Online Comment

Application H16-0480-21
Location THE GLASSHOUSE 2a BEECHFIELD GARDENS SPALDING PE11 1UN
Proposal Single storey extension to garage

Name Diane Fairchild
Address Conservation Assistant (Tree Preservation) Planning & Development

PROPOSED PLAN

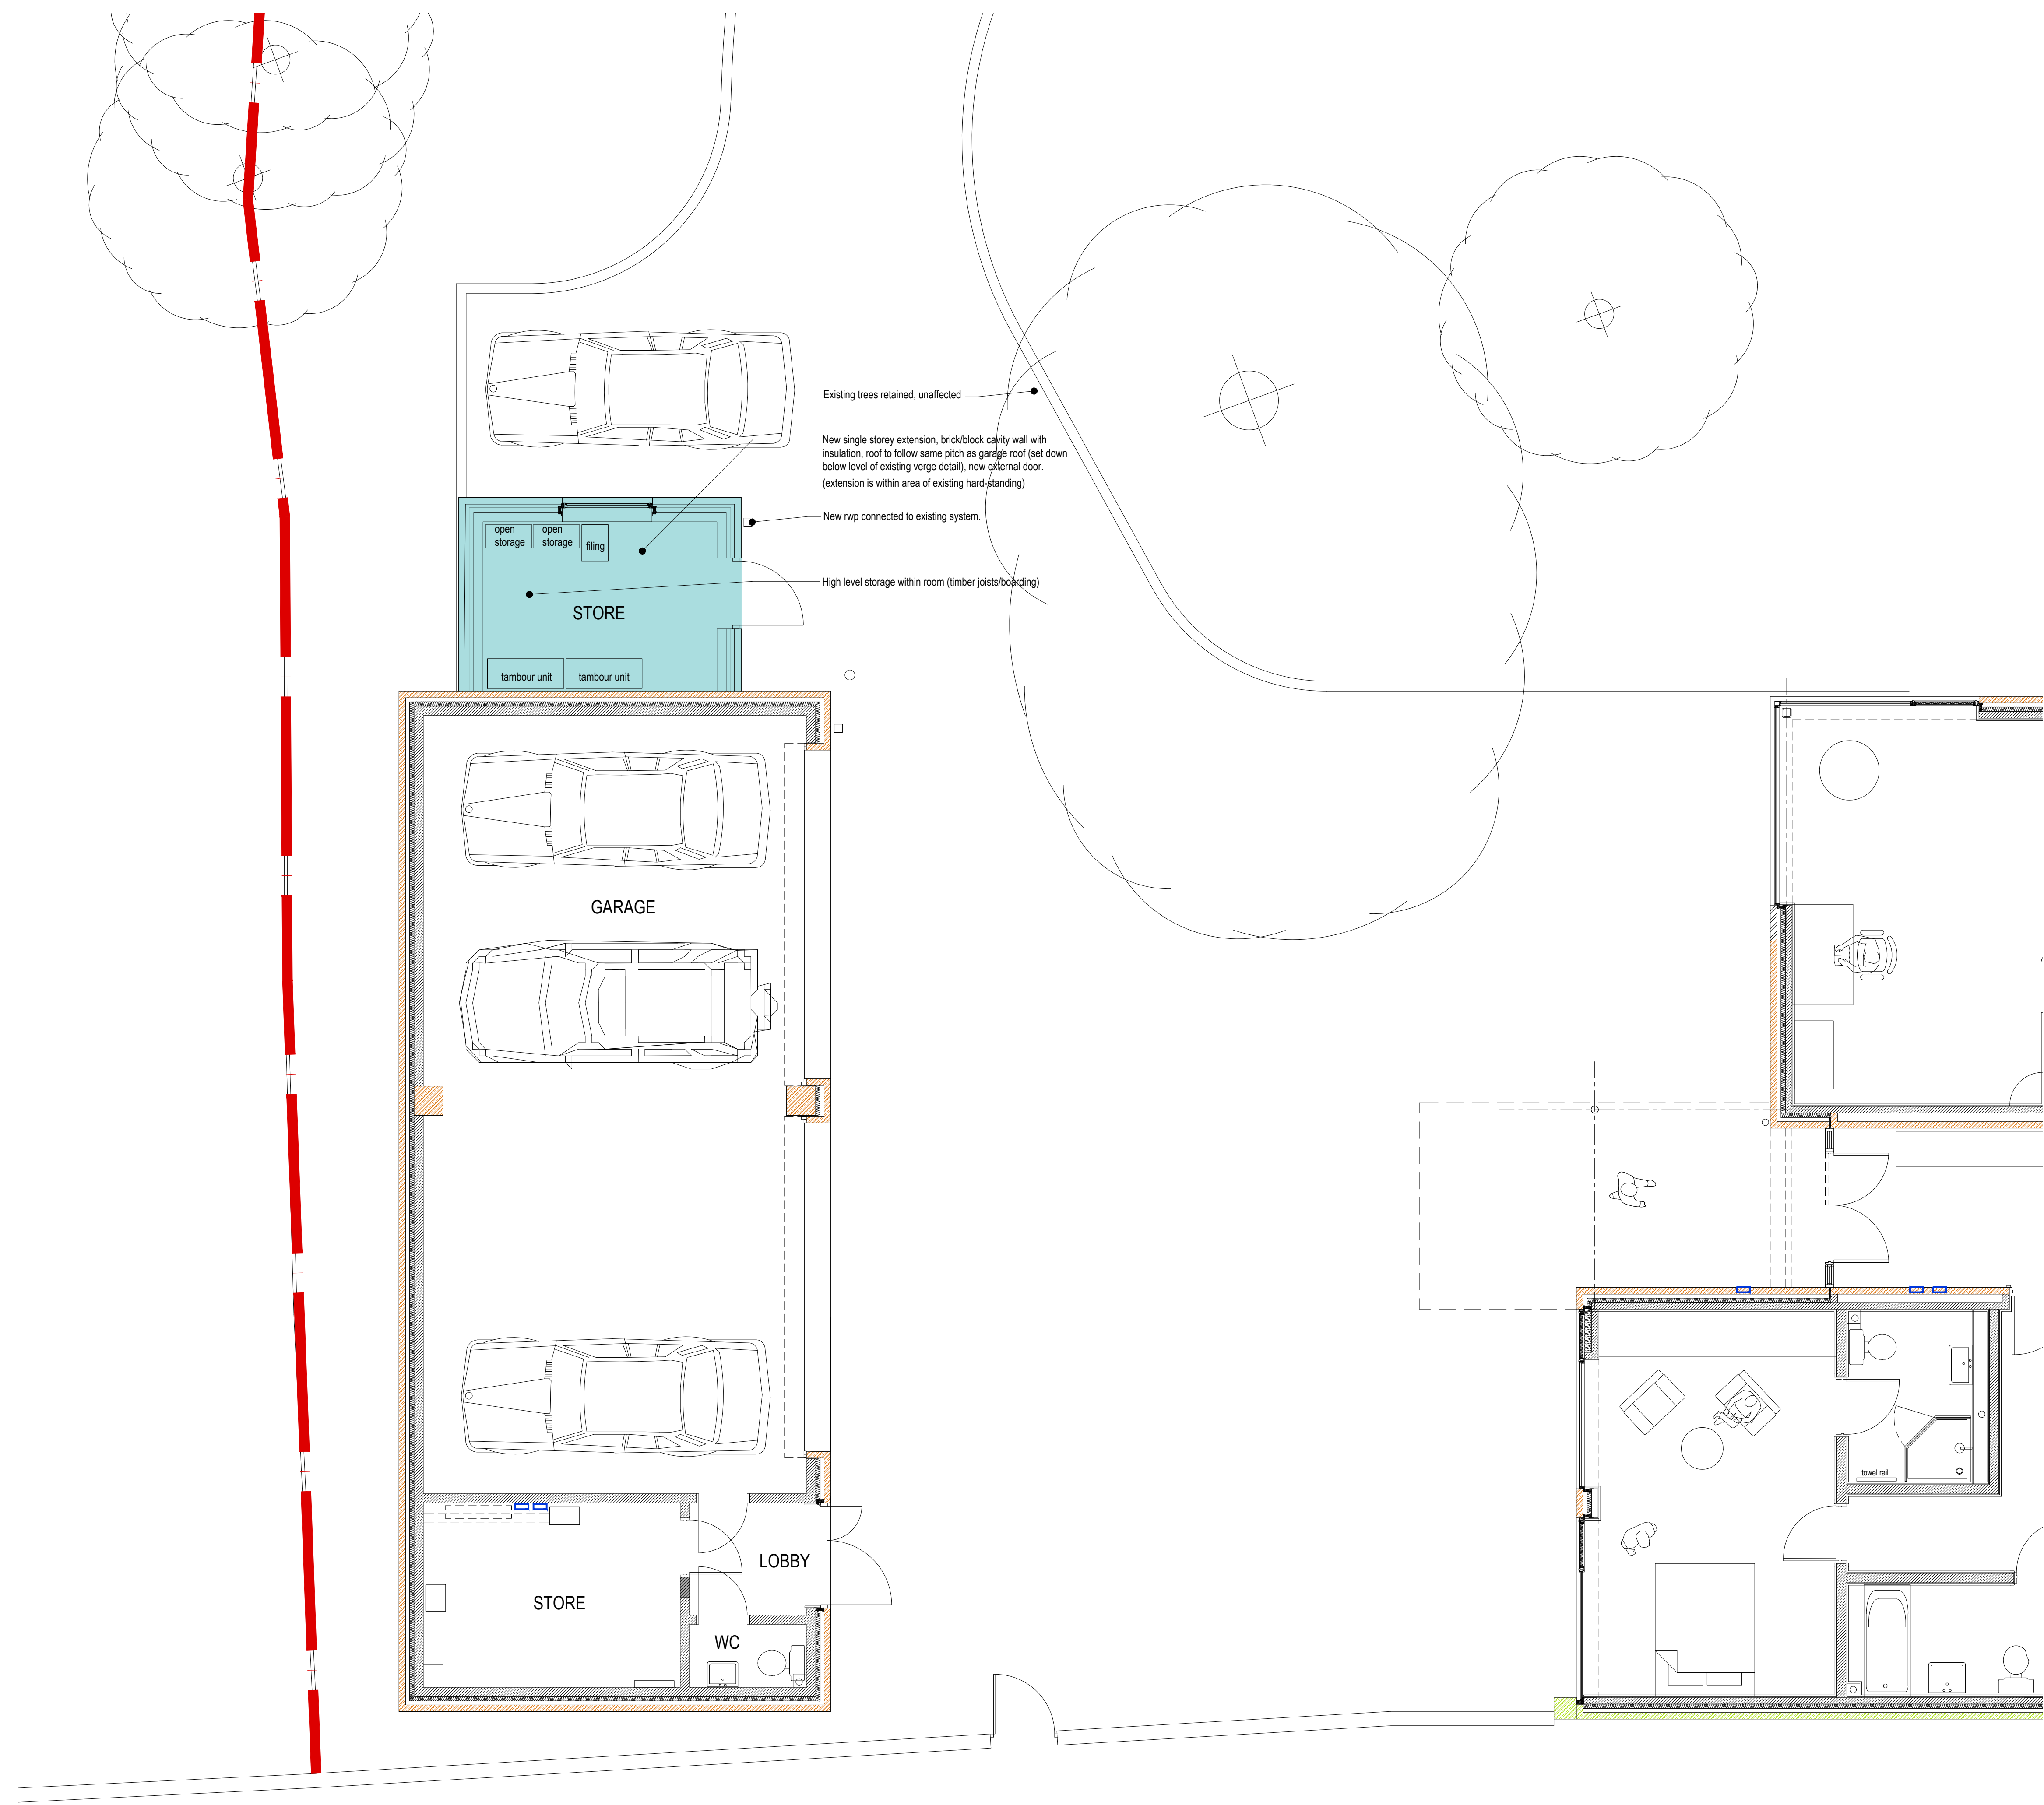
As the proposed extension is using the existing hard standing, can not foresee that it will have a detrimental effect on any significant trees.

Care will require to be taken of adjacent trees during construction works, ideally as recommended in British Standard BS 5837: 2012 .
